A1 in Northumberland TR010059

### **Northumberland County Council's Relevant Representation**

#### **Relevant Representation of Northumberland County Council under Section 56 of the Planning Act 2008 in respect of the A1 in Northumberland Development Consent Order Application.**

© WSP UK Ltd

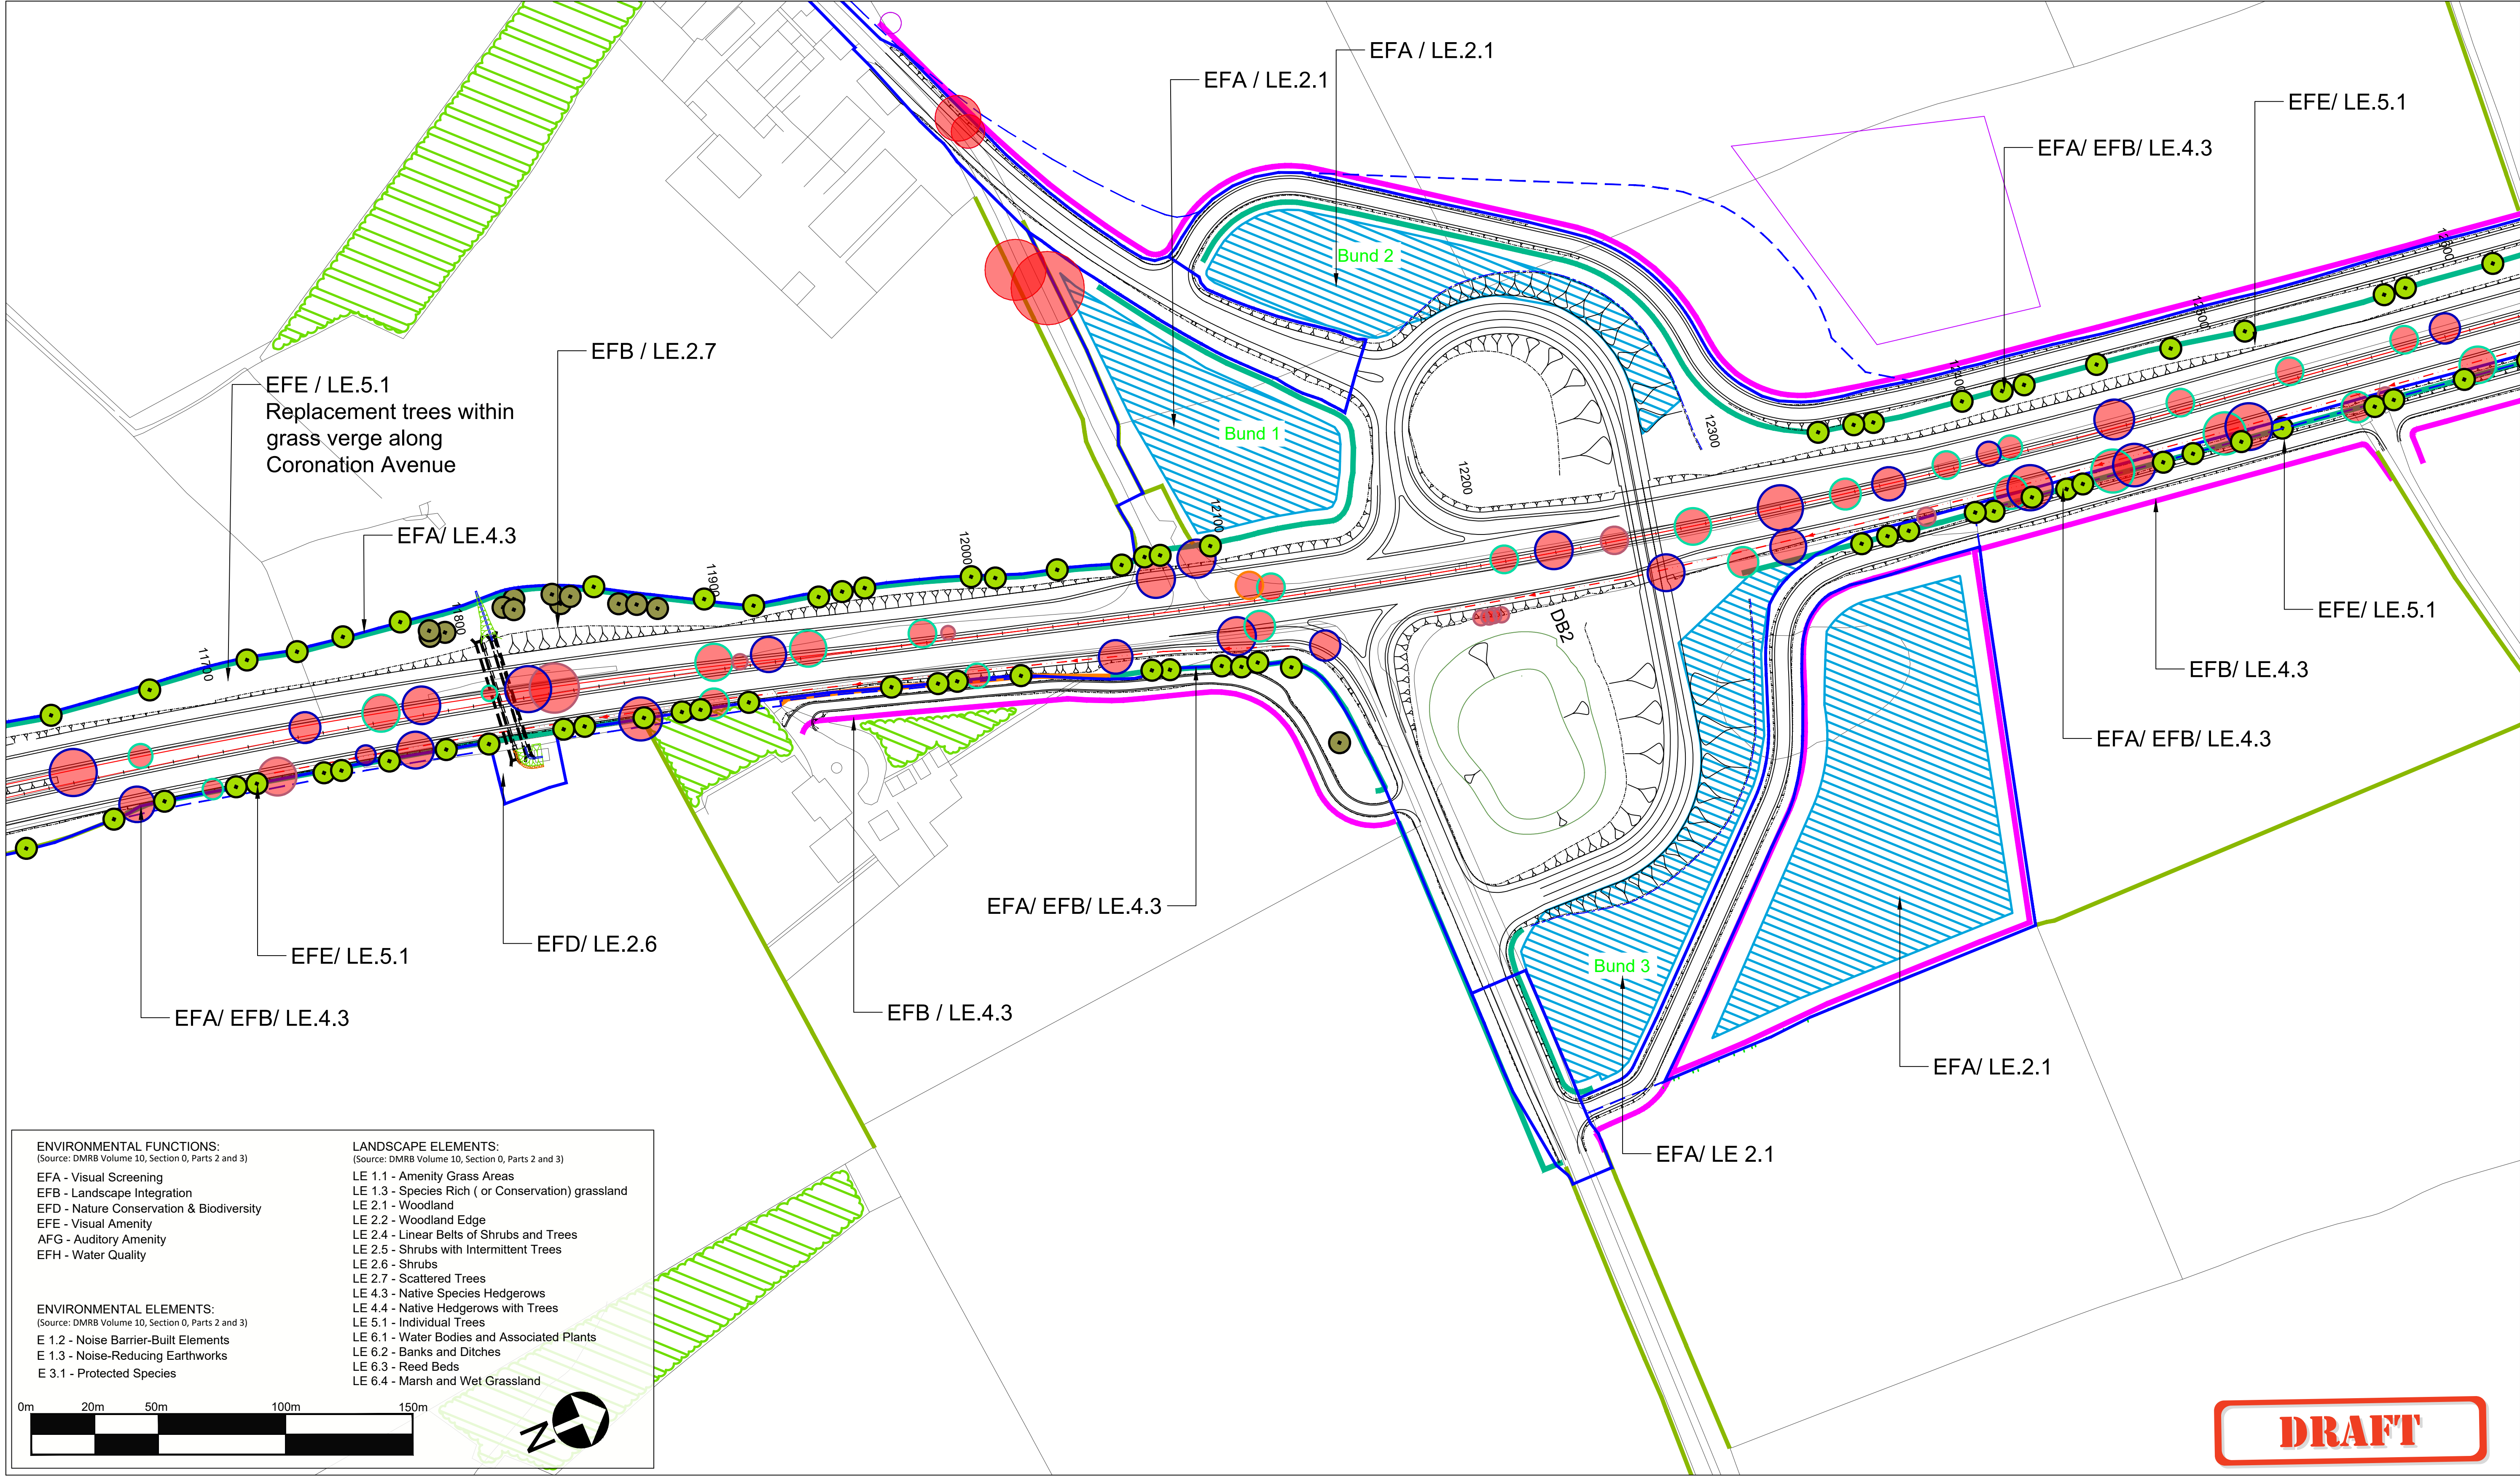
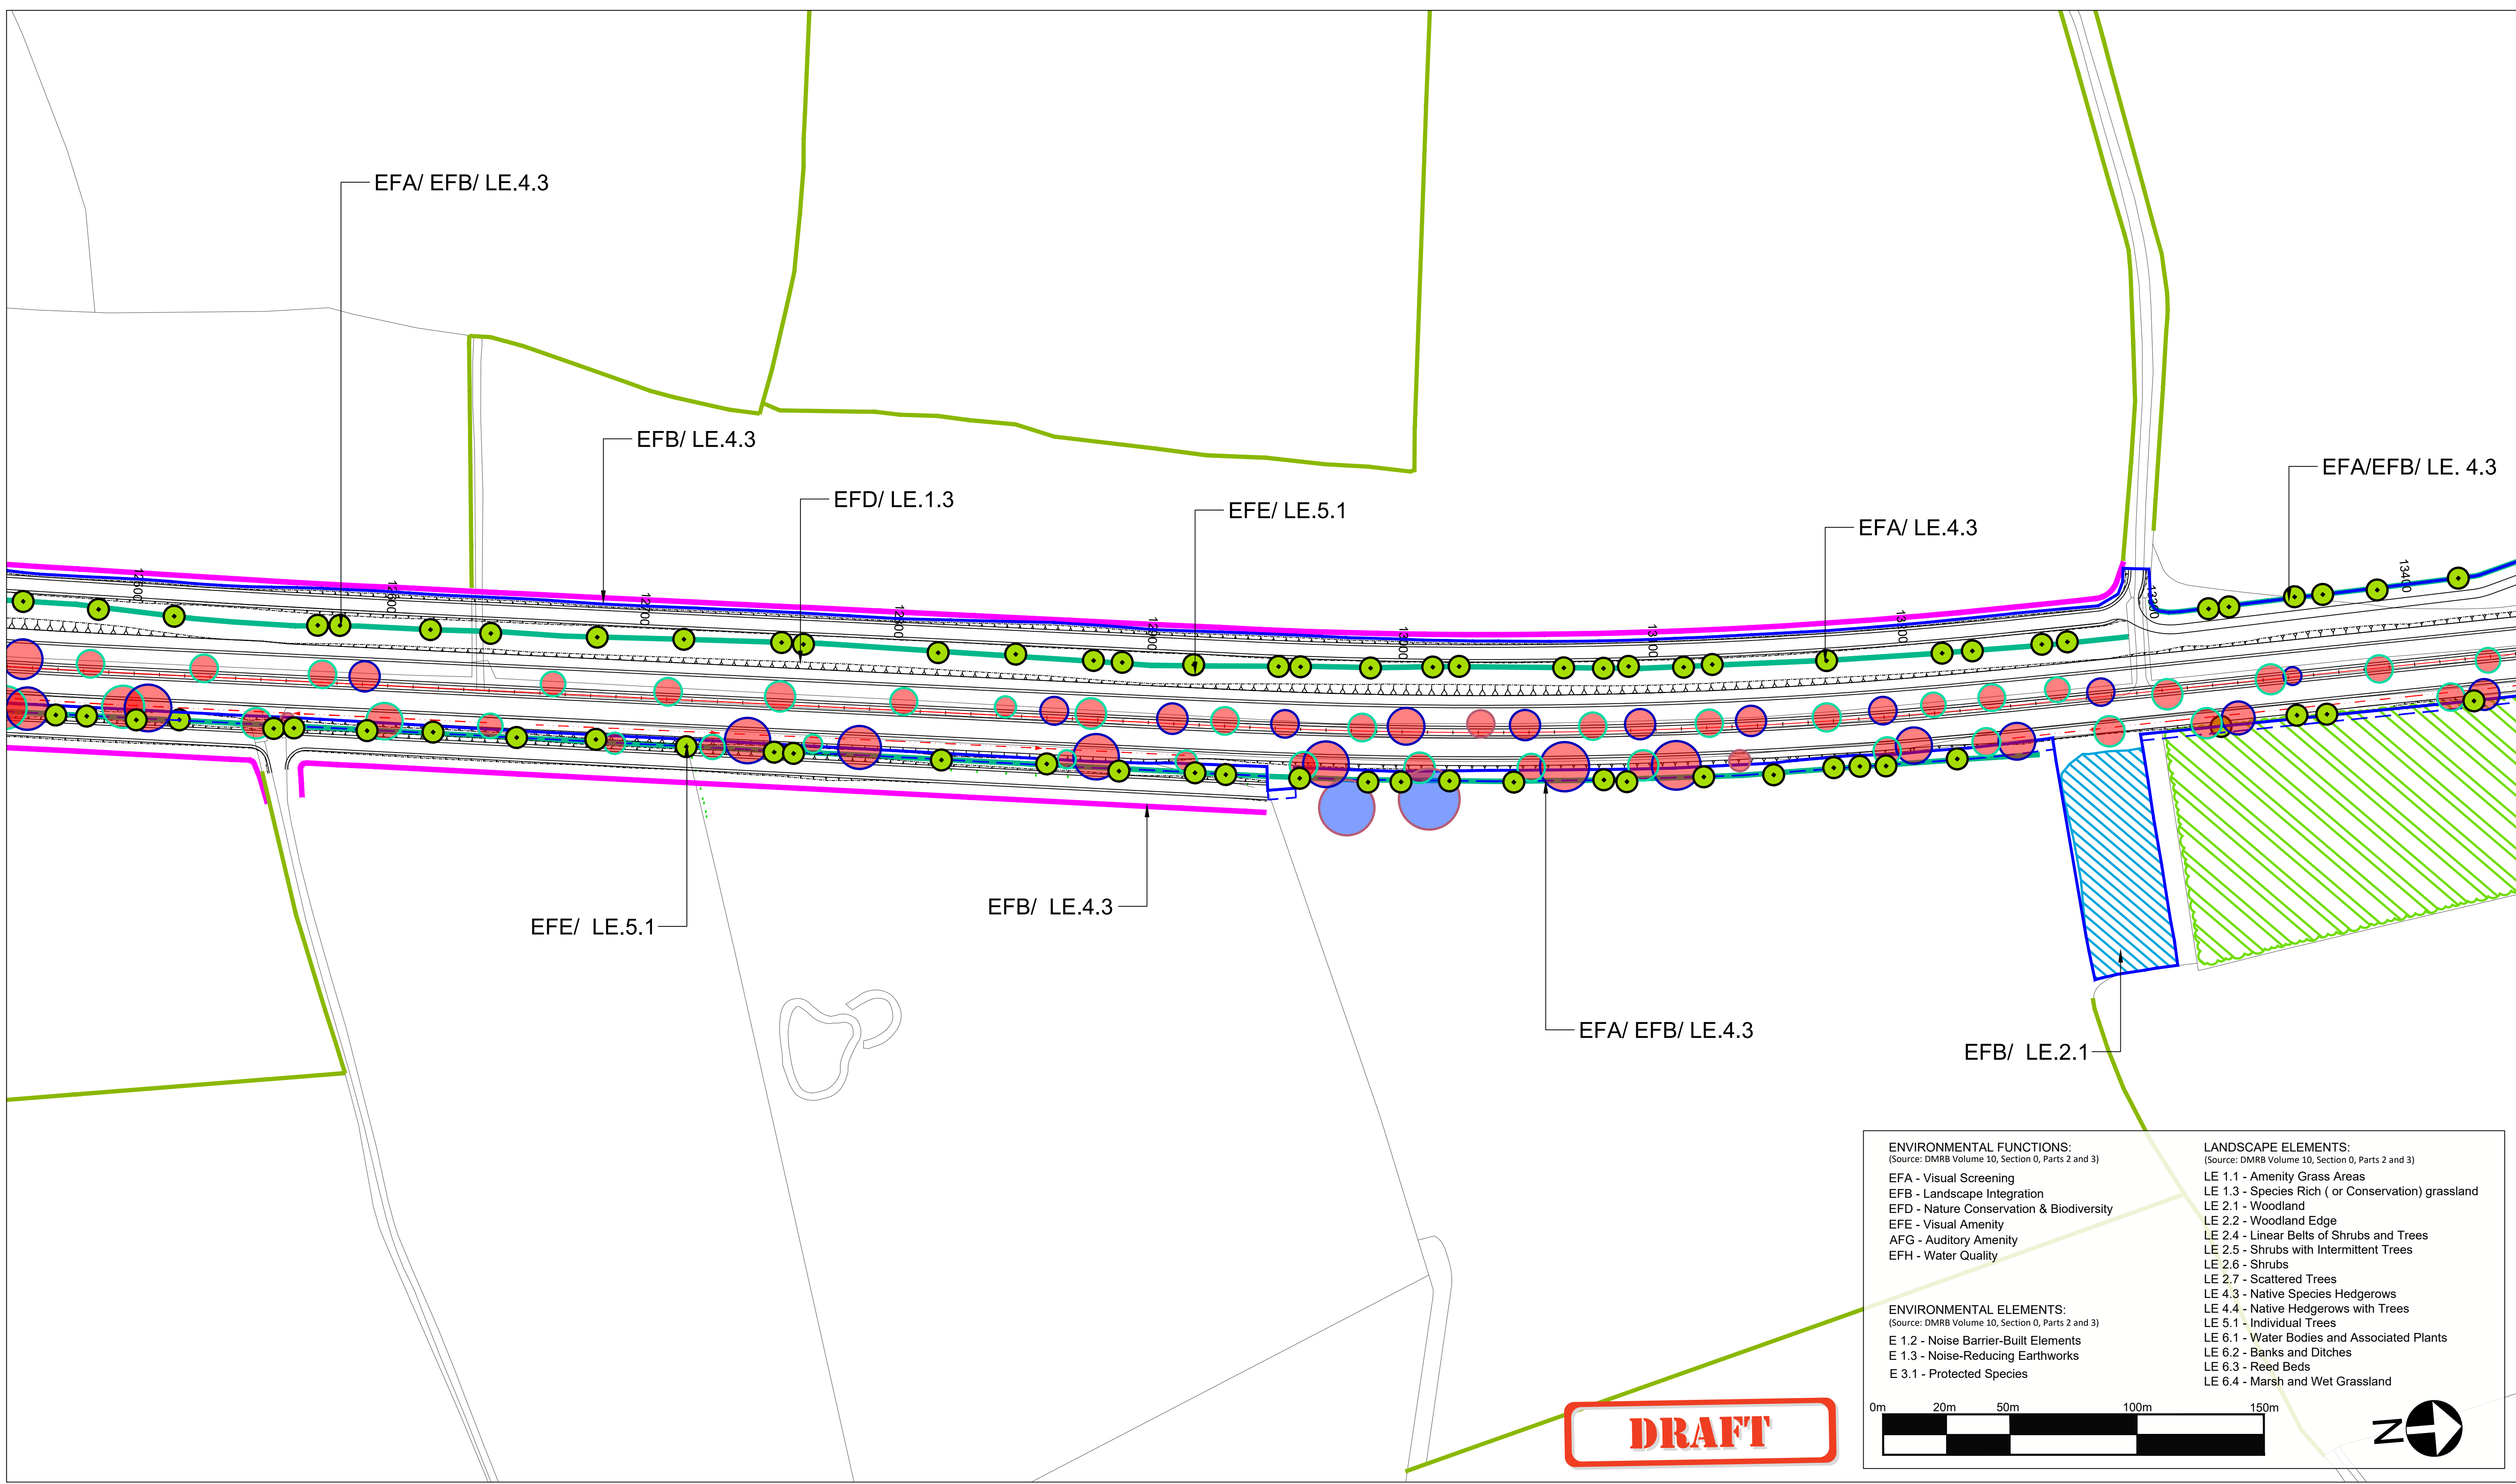
23. The replacement Coronation Avenue is a token gesture, consisting of trees spaced roughly every 100m. This avenue plays an important role in retaining a rural, well-vegetated character through this section of the route and the LVIA is quite clear about the local importance of the Avenue as a landscape feature and the sparse nature of the replacement compared to what is removed is not explained or justified in the application.

24. There is a lack of certainty and commitment in the landscape proposals, some of the bunds are described as 'desirable mitigation' and it is unclear as to whether they will be delivered or not. A number of the proposed hedgerows are marked as being 'by agreement' and the replacement avenue is described as 'currently proposed' and 'as appropriate and if required' suggesting that these elements are not a committed aspect of the proposals.
